Your ref: TR010066

Application by National Highways for an Order Granting Development Consent for the A46 Coventry Junctions (Walsgrave) Project – Deadline 2

Comments on Relevant Representations (RR) updated information.

ENVIRONMENTAL STATEMENT FIGURES
Figure 2.5 Temporary Works

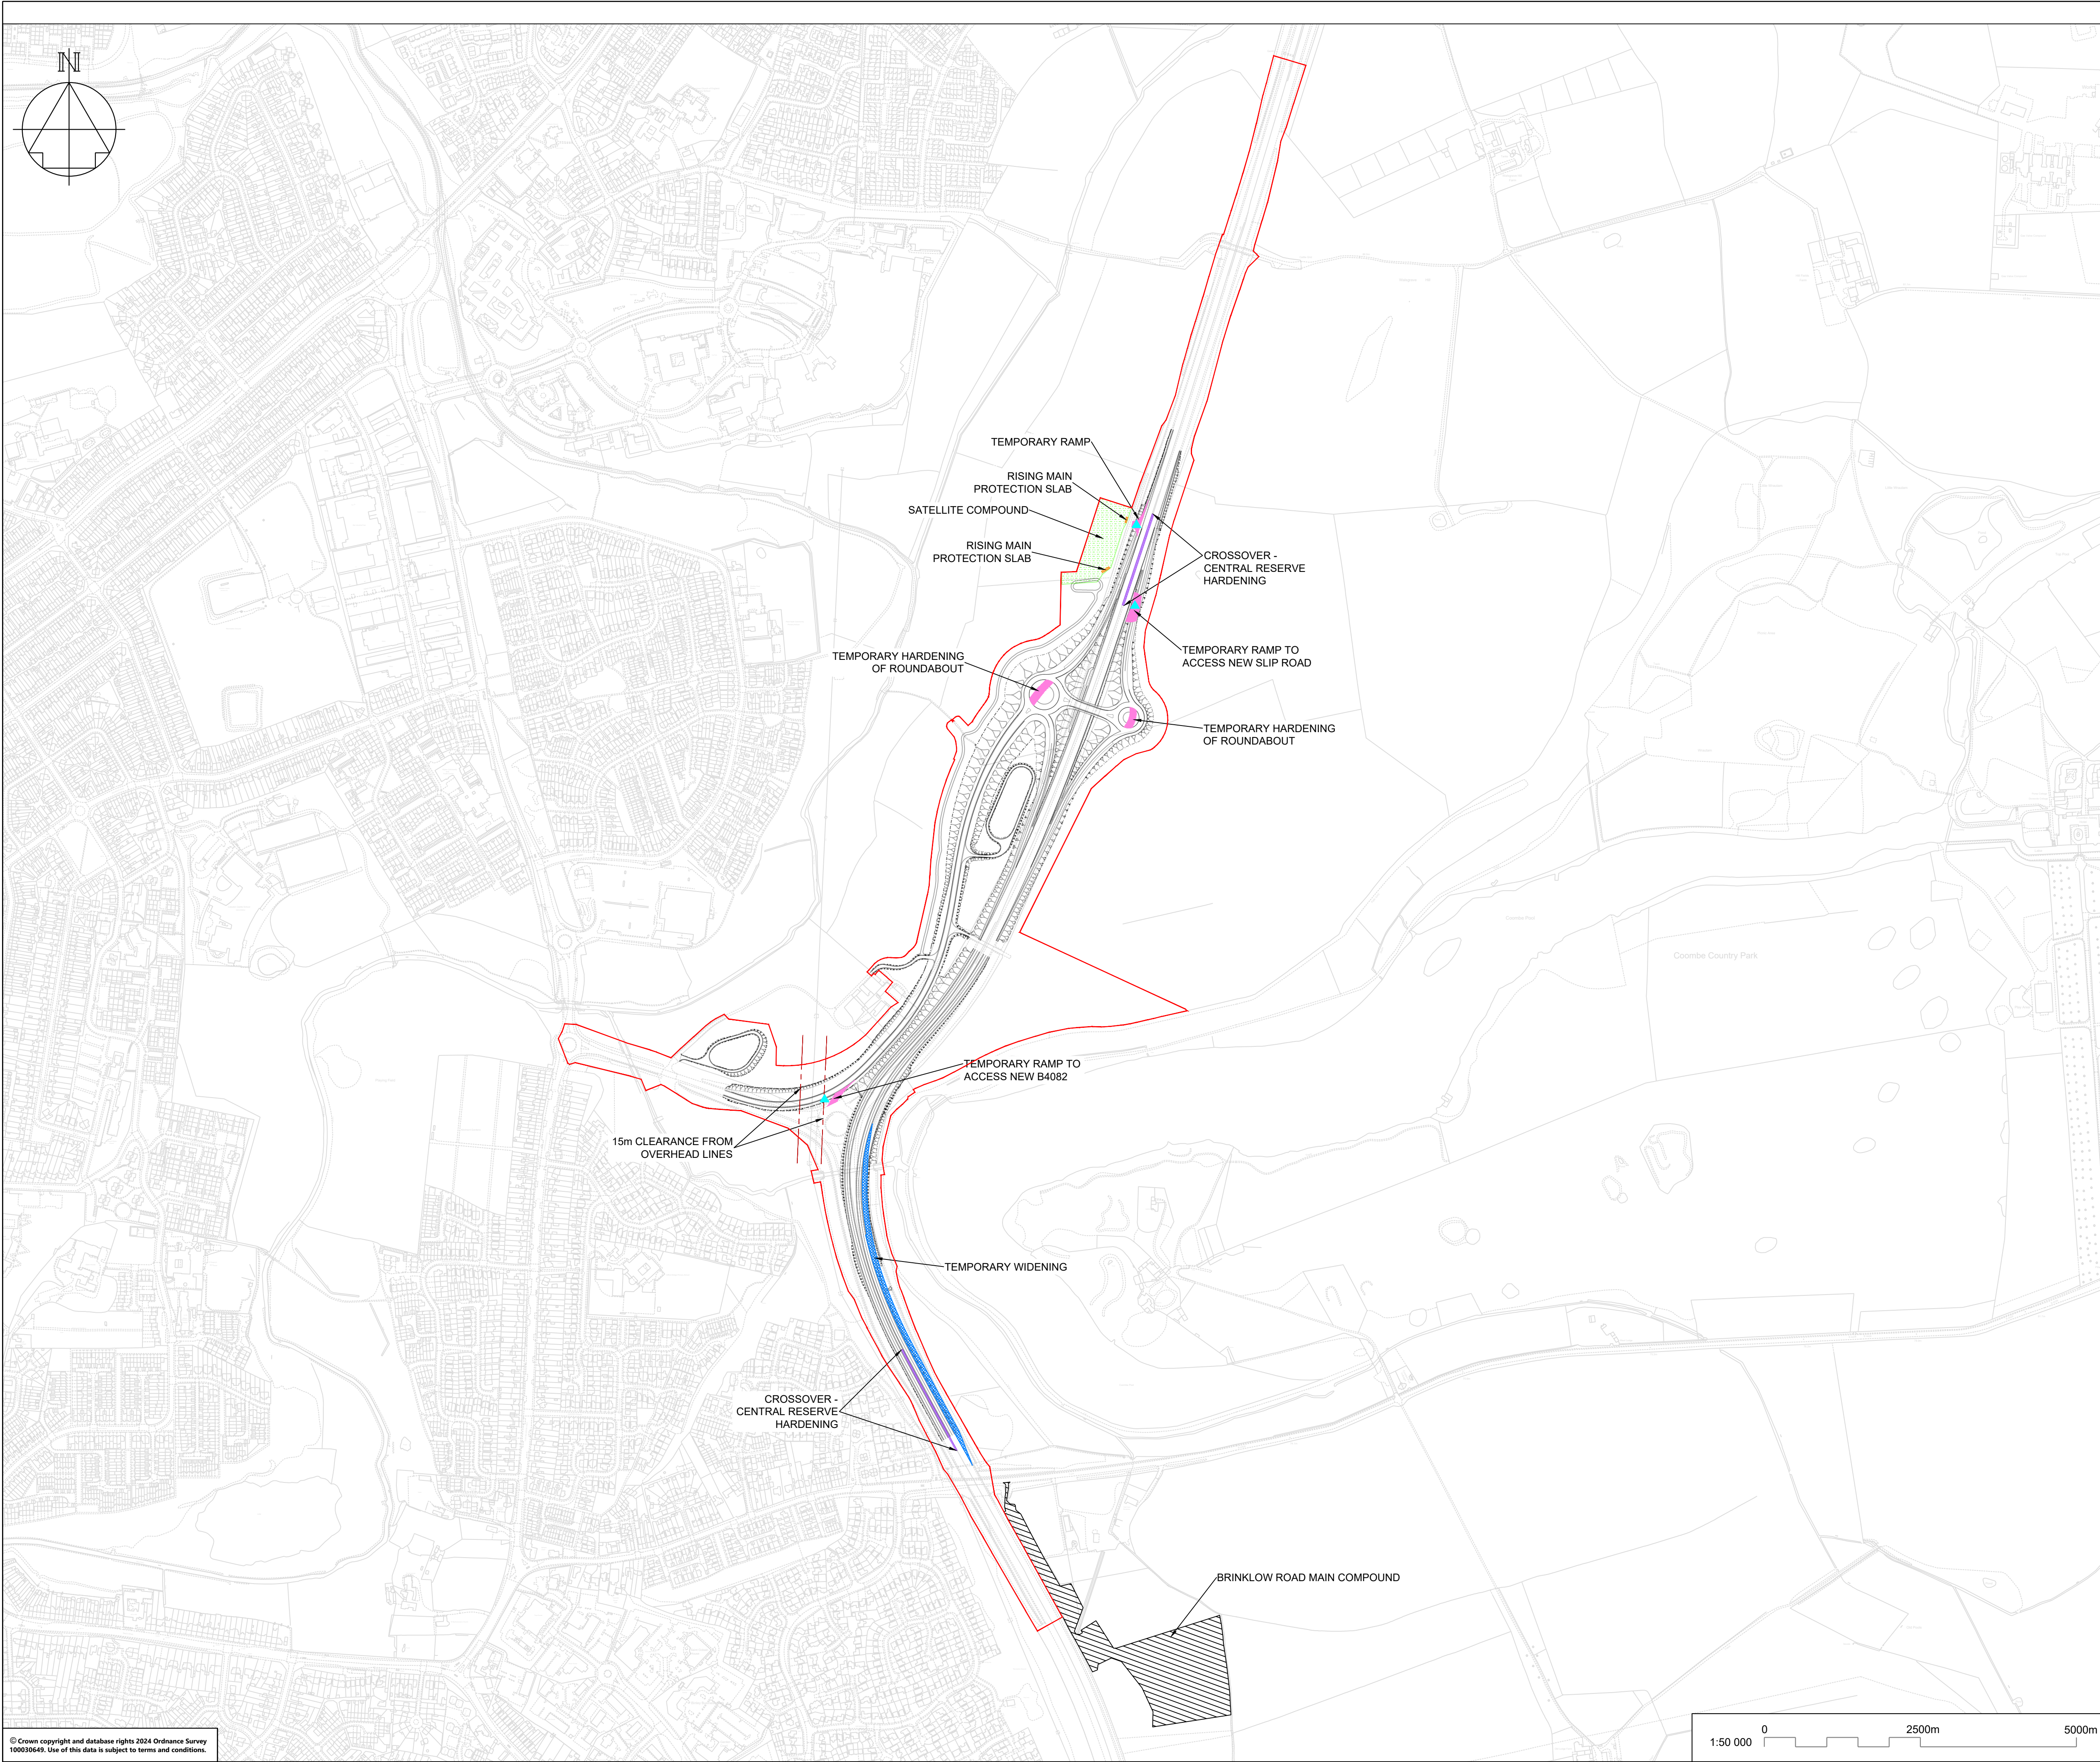
<p>apparent throughout the course of the works that additional permits are required, the Applicant will work with the relevant regulator to ensure these are obtained.</p>	
<p>9.2. Chapter 13 – Road Drainage and Water Environment</p> <p>It is noted in Section 13.6.3 that a temporary culvert is proposed over an unnamed ordinary watercourse. It would be useful if this temporary culvert could be shown on the temporary works plan (Figure 2.5 Temporary Works). This is an area shown as Flood Zone 1. The ephemeral watercourse on which this culvert would be located is not shown on the Detailed River Network. Any associated flood risk impacts of this temporary culvert crossing on flood risk would be negligible.</p> <p>9.3. Section 13.10.15 describes how flooding has the potential to impact construction workers, equipment, and the scheme. This section also notes that contractors should sign up to the Environment Agency's Flood Warning service. This is welcomed. With regards to construction compounds and materials these should be placed outside of the functional floodplain.</p>	<p>The temporary culvert is within the satellite compound (Work 4A) which is shown on the Works Plan (APP-013).</p> <p>The Applicant is in discussion with Coventry County Council and Warwickshire County Council, the two Lead Local Flood Authorities (LLFA), regarding obtaining appropriate consent for the works. This is detailed in 8.6 Statement of Common Ground with Coventry City Council (TR010066/EXAM/8.6) and 8.7 Statement of Common Ground with Warwickshire County Council (TR010066/EXAM/8.7) submitted at Deadline 1.</p> <p>Paragraphs 2.6.10 - 2.6.20 of ES Chapter 2 (The Scheme) (APP-024) outlines the construction compounds, which includes the re-use of the existing Brinklow Compound and the establishment of the satellite compound and bridge laydown area to the west of the A46, north of the new junction, as</p>	<p>Noted</p>

shown on ES Figure 2.5 (Temporary Works) (APP-044). These are not within the floodplain as shown in ES Figure 13.1 (Surface Water Features, Licensed Abstractions, Consented	
<p>9.4 Table 1312 - Potential residual effects on ground water and surface water receptors during construction of the scheme.</p> <p>This table identifies that construction activity has the potential to act as a barrier to flow redirecting flood risk to others. The proposed mitigation includes a temporary drainage strategy and adhering to the CIRIA guidelines on the control of water pollution. No mitigation appears to be proposed for the effects that construction activities might have on fluvial flood flows and loss of floodplain storage. Construction compounds and materials should be placed outside of the floodplain. Where this is not possible the impact on flood risk on construction activities should be quantified using the detailed hydraulic model developed for the scheme.</p>	<p>The Applicant confirms that no works are currently proposed in the floodplain of main rivers as detailed in paragraph 13.9.6 of ES Chapter 13 (Road Drainage and the Water Environment) (APP-035). However, as the Order Limits extend into the floodplain of a main river (the River Sowe), then a FRAP will be sought by the Applicant for any works that are required within the floodplain, in which the flood risk will be demonstrated to the Environment Agency for approval.</p> <p>The Satellite Compound and temporary constructions works are shown on ES Figure 2.5 (Temporary Works) (APP-044) and are located outside of the flood plain, which is shown in ES Figure 13.1((Surface Water Features, Licensed Abstractions, Consented Discharges and Fluvial Flood Risk) (APP-059).</p>	Noted

Plate 1: section east of the A46 culvert and approximate surveyed module (blue line)

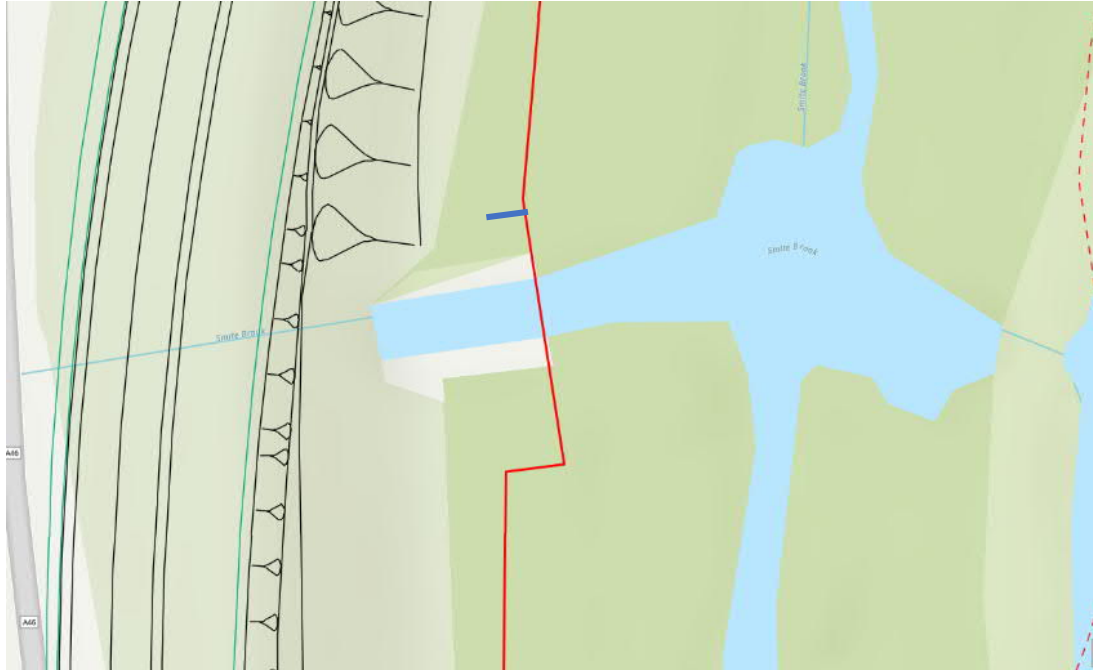
<p>6.3 Environmental Statement Appendices: Appendix 8.1 Biodiversity Net Gain Report 4.5.1</p> <p>Issue - Following construction, the watercourse units are predicted to be the same prior to construction (0.71 units), so there is 'no net loss'.</p> <p>Impact - No enhancements to watercourses within the scheme under BNG have been proposed, the aim of BNG to make sure developments have a measurably positive impact on biodiversity.</p>	<p>As detailed within ES Appendix 8.1 (Biodiversity Net Gain Report) (APP-076) as an NSIP submitting a DCO application in late 2024, the Scheme is not subject to mandatory BNG under the Environment Act 2021, which is due to come into force for NSIPs in November 2025. The Scheme is a transition scheme sitting within the RIS2 period (2020 – 2025) and as such the Applicant has set a +10% BNG</p>	<p>The EA are not a direct statutory body for BNG but we encourage the applicant to provide for linear watercourses where possible.</p>

<p>Solution - The scheme should consider in-channel or riparian enhancements. The negative indicators recorded during the MoRPH survey (e.g. Sections 3.4.6 & 3.4.9) could be used as a guide (e.g. remove physical modifications/artificial banks and manage INNS on Smite Brook).</p>	<p>target for both area-based habitats and linear-hedgerow habitats. There is no target set by the Applicant regarding linear watercourse habitats.</p> <p>The Scheme will have no direct impacts on any features qualifying as watercourses under the Statutory Metric guidance (i.e. excluding ephemeral ditches). Impacts to watercourses (as considered under the Statutory Metric) and their riparian zones are limited to some temporary habitat loss and postconstruction change in habitat in a small area of the Smite Brook riparian zone. The baseline and projected postconstruction biodiversity units for linear watercourses have been calculated and presented within ES Appendix 8.1</p> <p>(Biodiversity Net Gain Report) (APP-076), including accounting for the change in Smite Brook riparian zone, to provide a complete and transparent picture of the change in biodiversity due to the Scheme. The calculations evidence 'no net loss' to watercourses and as such are in support of no impacts.</p> <p>The Scheme includes enhancement to the wider water environment within the Order Limits, which</p>
